Falcon Landing

7344 McLaughlin Road Falcon, Colorado 80831

PROJECT: BECKETT AT WOODMEN HILLS LOT 3
SHEET TITLE: SITE PLAN
FROM: n/a TO: n/a
JOB NO. 06-0056 SHEET 1 OF 1

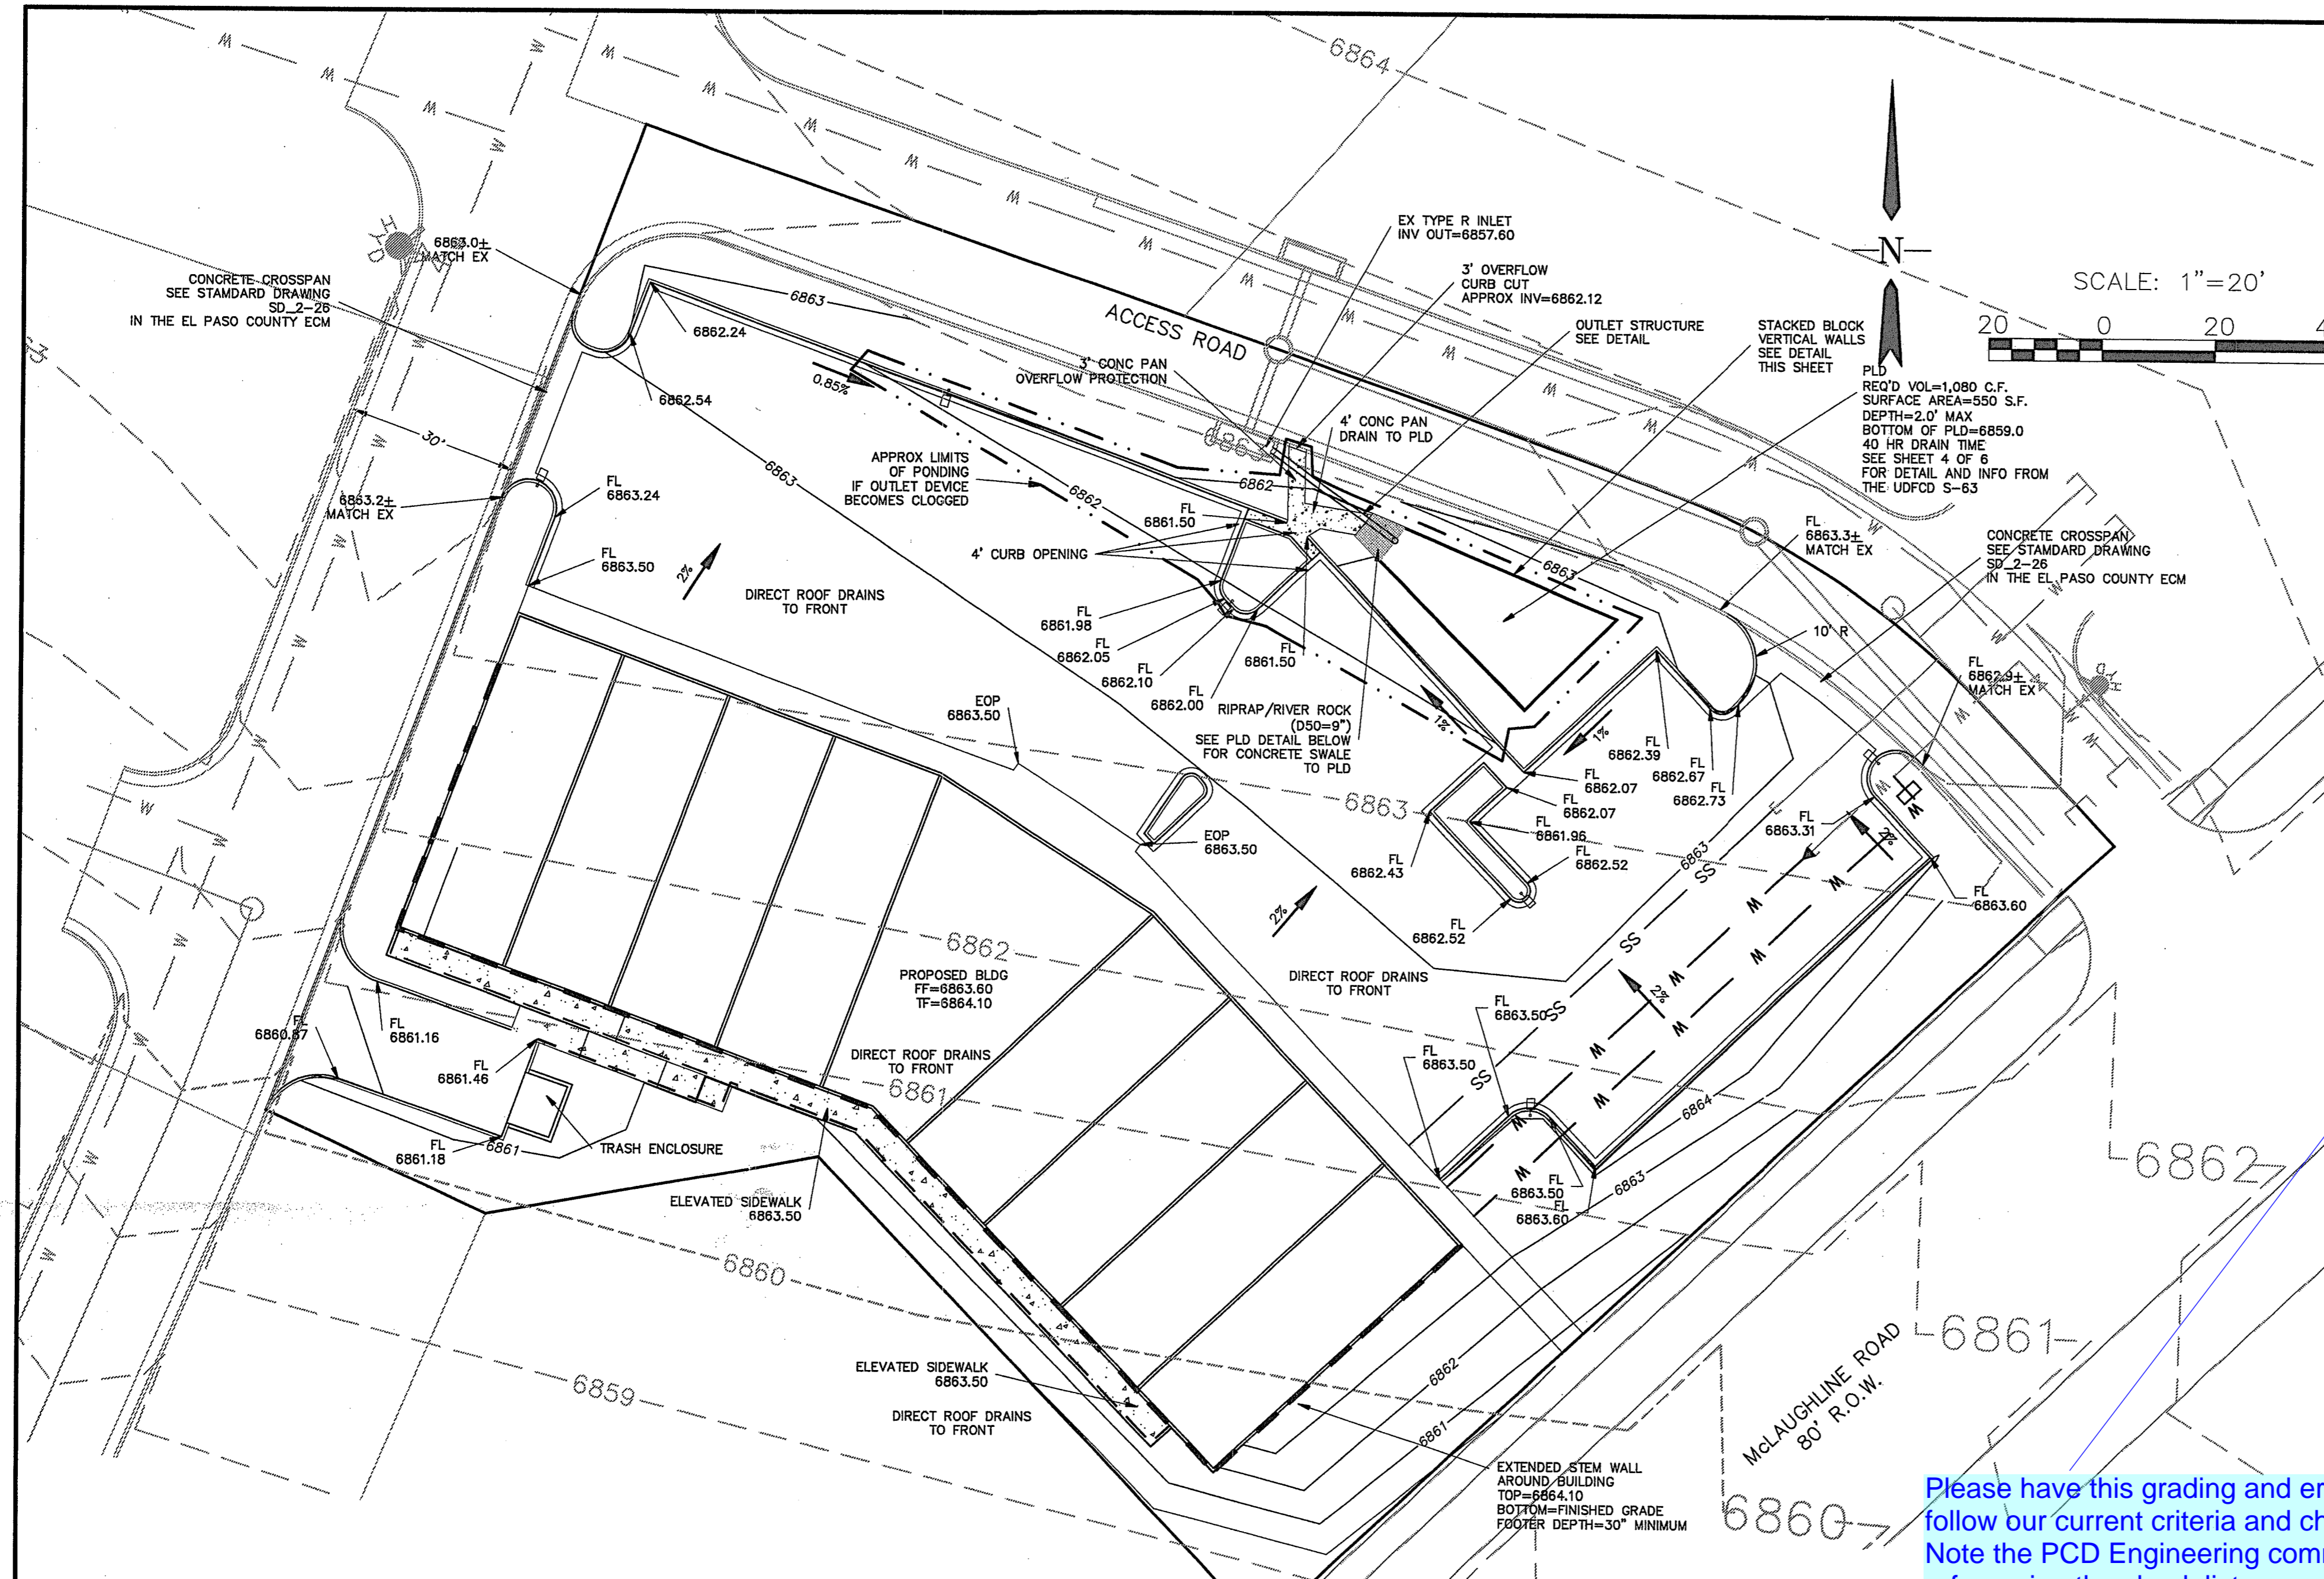
Add the following note: Certified percolation tests are required to be submitted to PCD Engineering and written approval from PCD Engineering is required prior to elimination of the Gravel layer, underdrains and geotextile fabric.

Ensure that ADA requirements are met here and throughout site. Provide the std. note on site plan sheet.
